From: ROBERTS, FRANCES A CIV USSF SpOC 21 CS (OL-S)/SCXF
<frances.roberts@spaceforce.mil>
Sent: Thursday, February 22, 2024 10:03 AM
To: Eron Haxhimehmeti
Cc: Arends, Nicholas J [US] (SP); Roberts, Mark R [US] (SP); Joe Letke; HORSTMEIER, DARREN T CIV USAF SPOC 50 CES/CENPL; Hana Bajrami; Festim Uka; Danielle Rizzo; FARR, ANDRAE D CIV USSF 21 CS (OL-S)/OL-S
Subject: RE: Request for Submittal - VZW_14424215/ ATC_419744- Site Address: 1100 S. Enoch Road

SHEET NUMBER: **C-401** REVISION: **0**

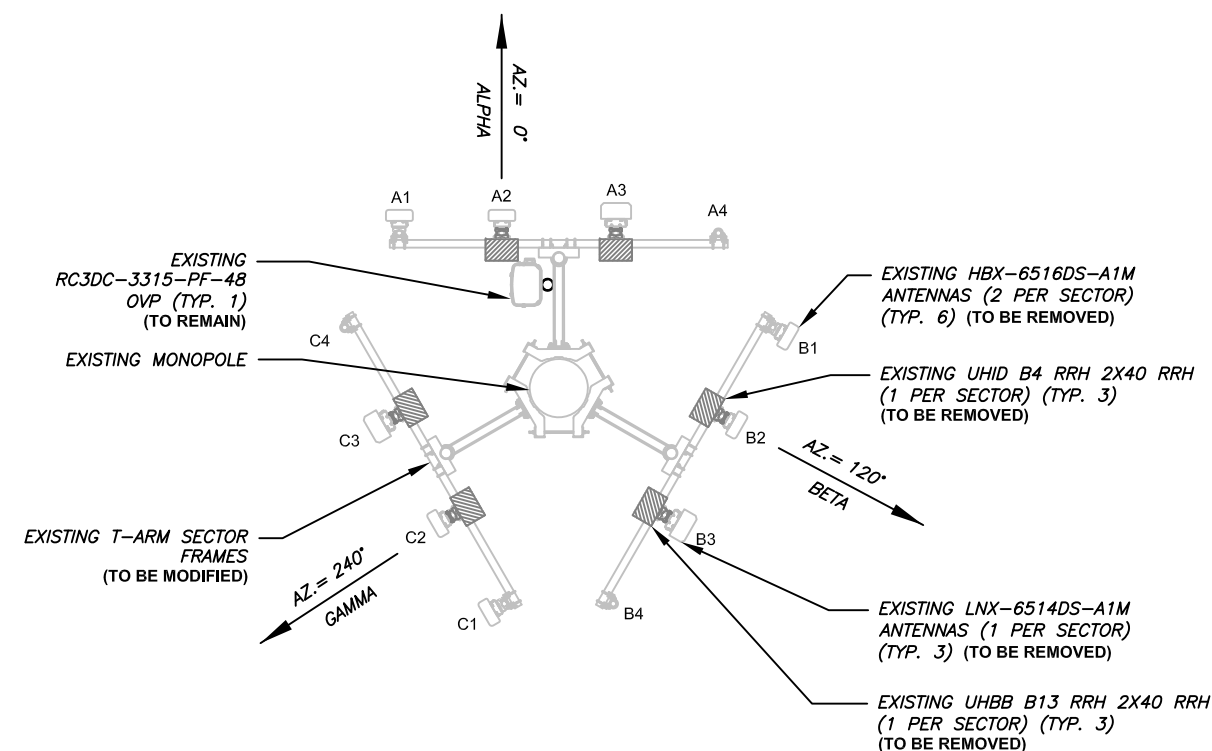
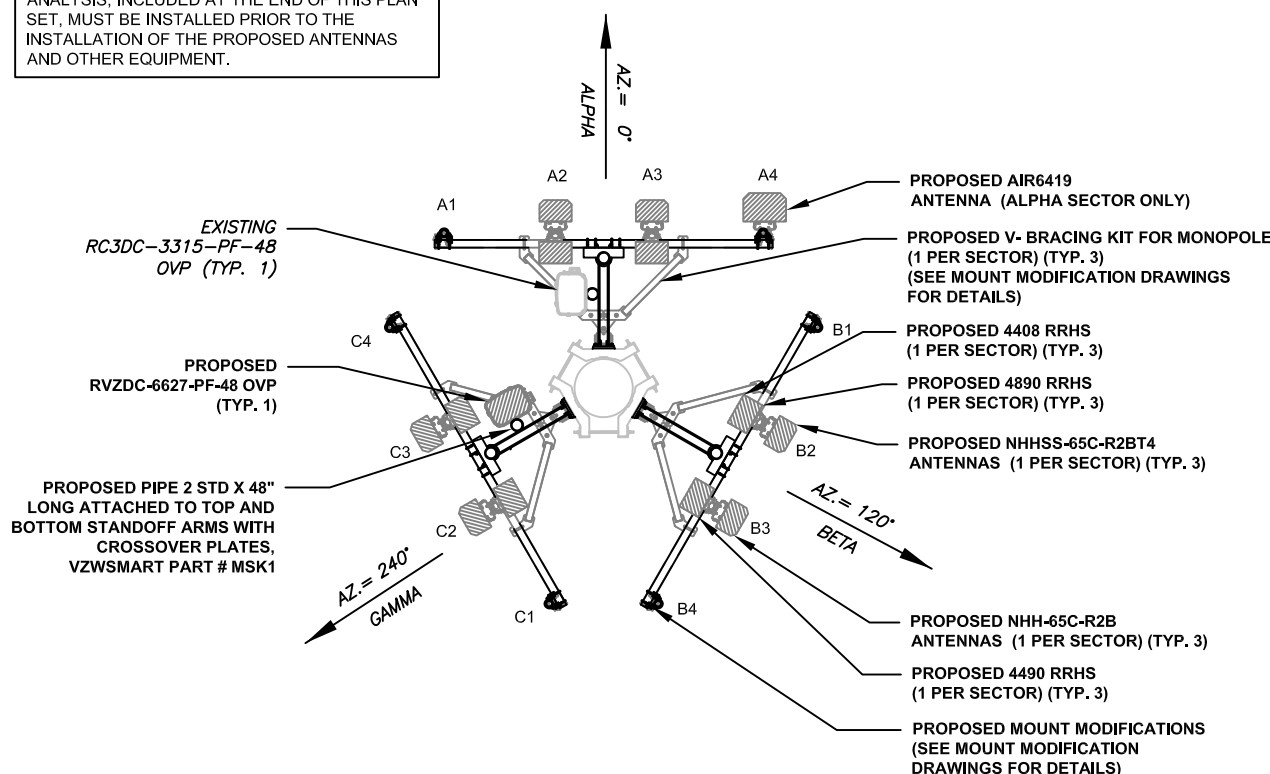
- Why is the power increasing so much? (The 746-757 MHZ is to increase from 80W to 120W. The 2115-2130 MHz is doubling.)
- Which way is the A4 panel going to be pointing?
- Need to provide a coverage plot of the existing system, and one of the proposed system to see how they will differ because of the increased power.

Just checking in to see if you are making progress with the spectrum plots. These are highly pivotal as to whether we can concur or non-concur with your upgrade plans. We also need to know if the panels are directional and what direction you plan on pointing them.

Can we get spectrum plots from their transmitters, and if these will be directional with what directions they intend to radiate?

Received the frequency information. But, may I get a copy of the current setup so I can compare the changes?

- 1) Will you be using the same frequencies on the new panels that you are currently using on the old panels?
- 2) Will the power levels change any from the old to the new?
- 3) Will all of the panels be using the same frequencies?

Please find attached the table with each antenna matched to each frequency band and radio power. The information provided matches the table on sheet C-401 of the CDs.

- 1) Will you be using the same frequencies on the new panels that you are currently using on the old panels? – **Yes, plus some new frequencies, all licensed by the FCC:**
 - **746-757 MHz**
 - 880-890 MHz**
 - 2115-2130 MHz**
 - 2170-2180 MHz**
 - 1965-1970 MHz**
 - 3550-3860 MHz**
- 2) Will the power levels change any from the old to the new? – **Yes, the power levels will change from the old to new ones.**
- 3) Will all of the panels be using the same frequencies? – **No. (Please see question 1)**
